Subject: Footing Projection at 422 Hillandale Rd, Spring Lake, NC

APPENDIX G

Residential Single-Family Project: <u>(Y)</u> N	Commercial Project: Y <u>(N)</u>
Project Name: <u>REAR PATIO</u>	Permit No:
Project Address: <u>422 Hillandale</u> <u>Spring Lake, NC 28390</u>	Owner:
Date Inspected: <u>October 7, 2025</u>	Suite No:
Contractor Name: <u>H5R/All Build</u>	
Component Inspected: <u>Patio Wall Footing</u>

Monolithic Slab Detail @ Covered Patio

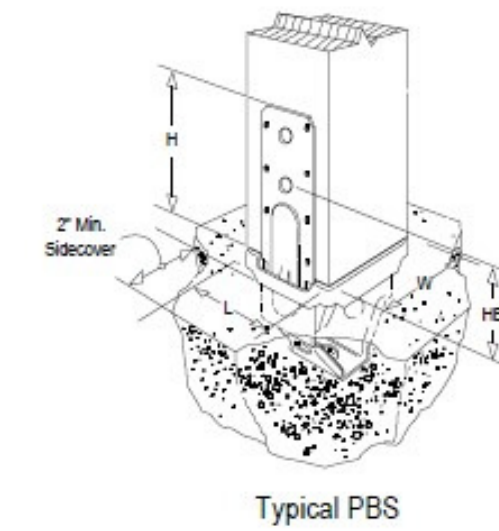
Per your request, I met with you at 422 Hillandale Rd to view the foundation and brickwork for a patio addition. Please see attached pictures showing the as-built condition of the 4" brick wall sitting upon a 9" deep by 18" wide concrete footing.

NC Residential Building Code R403.1.1 calls for a 2- inch projection. Most of the wall has between 2 and 4 inch projections except at a short section of the wall which reveals less than that. Due the short height of the wall with minimal load/overturning forces and being well-constructed, **I feel that the wall as built is well adequate to perform the intended function to support the patio slab being constructed.**

See attached Appendix G form approving this installation. Please let me know if you have any questions.
